The Planning & Environment Committee of Barnham and Eastergate Parish Council has considered the above application via an email exchange and wishes to raise an objection as follows:

Application No:	WA/85/20/DOC
Registered:	3rd November 2020
Site Address:	Land to the East of Fontwell Avenue Fontwell
Description of Works:	Approval of details reserved by condition imposed under ref APP/C3810/V/163143095 (WA/22/15/OUT relating to Condition No 5 - scheme of phasing for construction.

Drawing Title
Phasing Plan

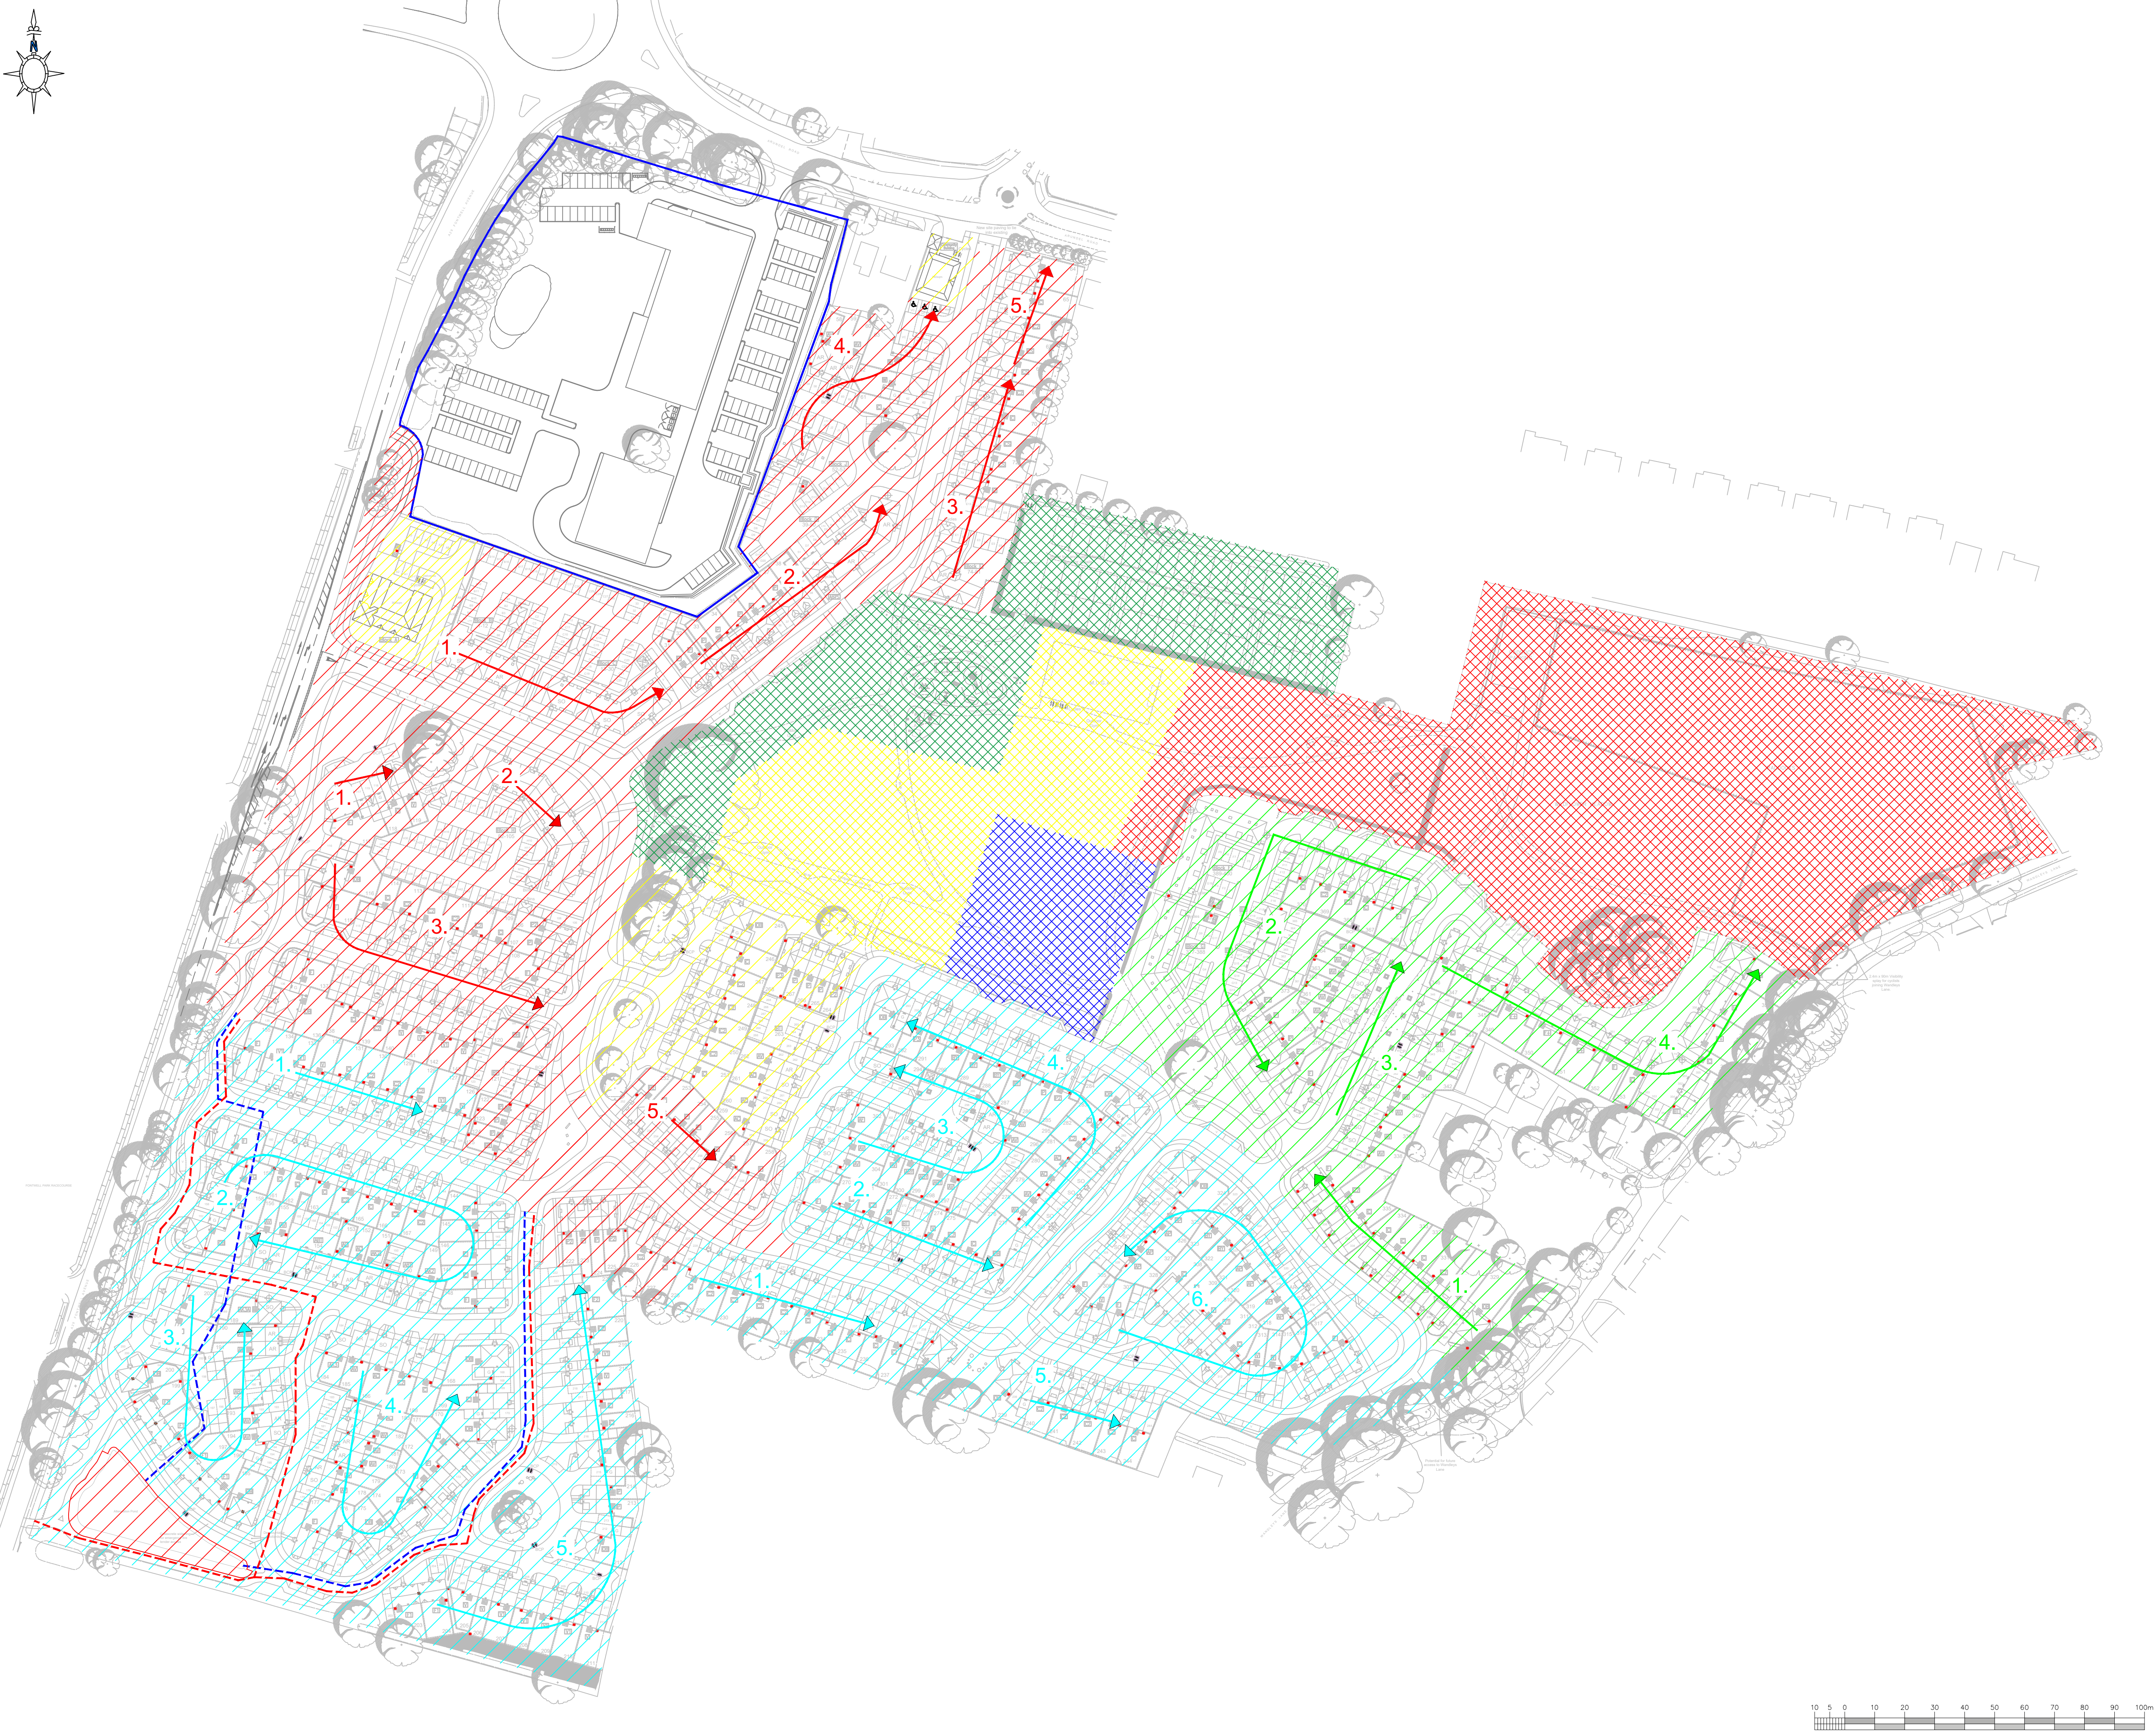
The Committee objects most strongly to commencement of any construction phase of the development until the issue of the proposed removal of the ancient and "important" hedgerow (or any part thereof) on the site is resolved to the satisfaction of the Parish Council and also CPRE who have expressed their concerns over its removal (letter dated 16/10/20). In addition, BEPC objects most strongly to commencement of any phase of development until concerns raised by the Environment Agency (letter dated 29/9/20) are addressed to the satisfaction of BEPC and EA.
